Listed building consent for remedial, health & safety works, fire alarm and emergency lighting installation, replacement windows and bin store re-arrangement.

Surgery, 85 The Street Rustington

Thank you for your internet representation made on 5th August 2019 which has been recorded as '**no objection**' with the comments as follows:

DRAWING PROPOSED GROUND FLOOR WORKS

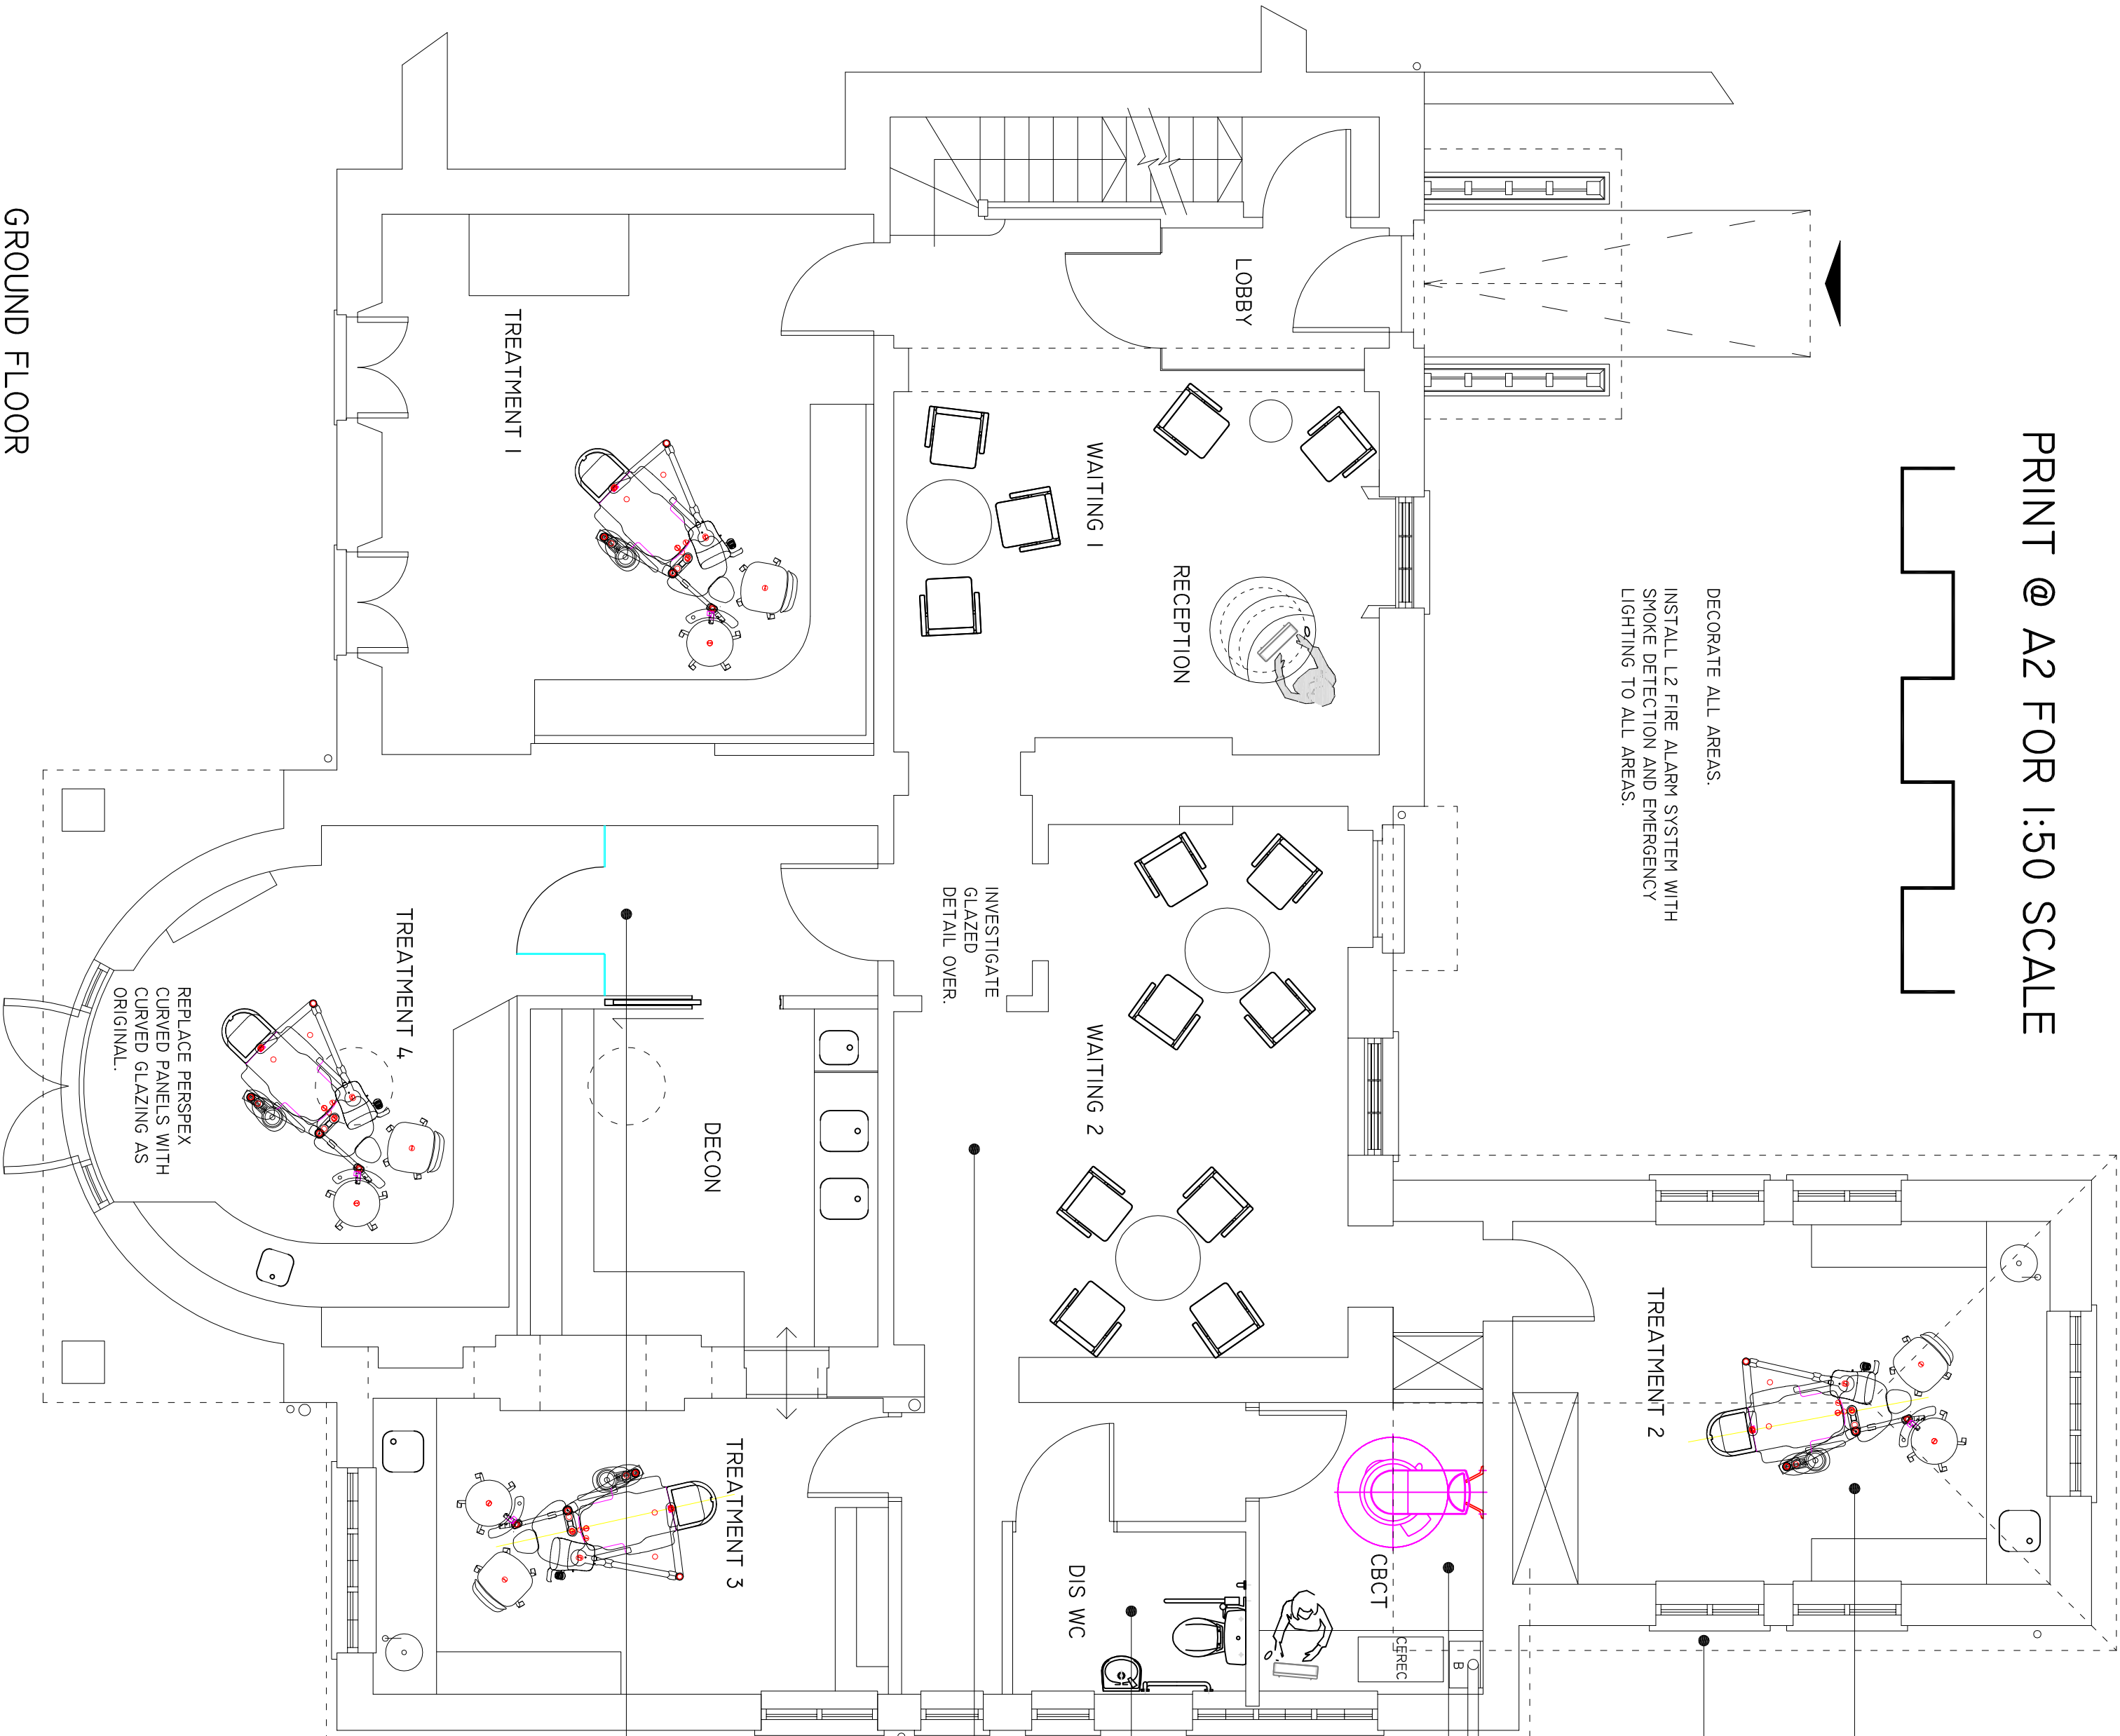
The proposal will enhance the appearance of the conservation area. It is suggested a condition be attached to the planning permission requiring the precise details of the new joinery be submitted to the Planning Officer.
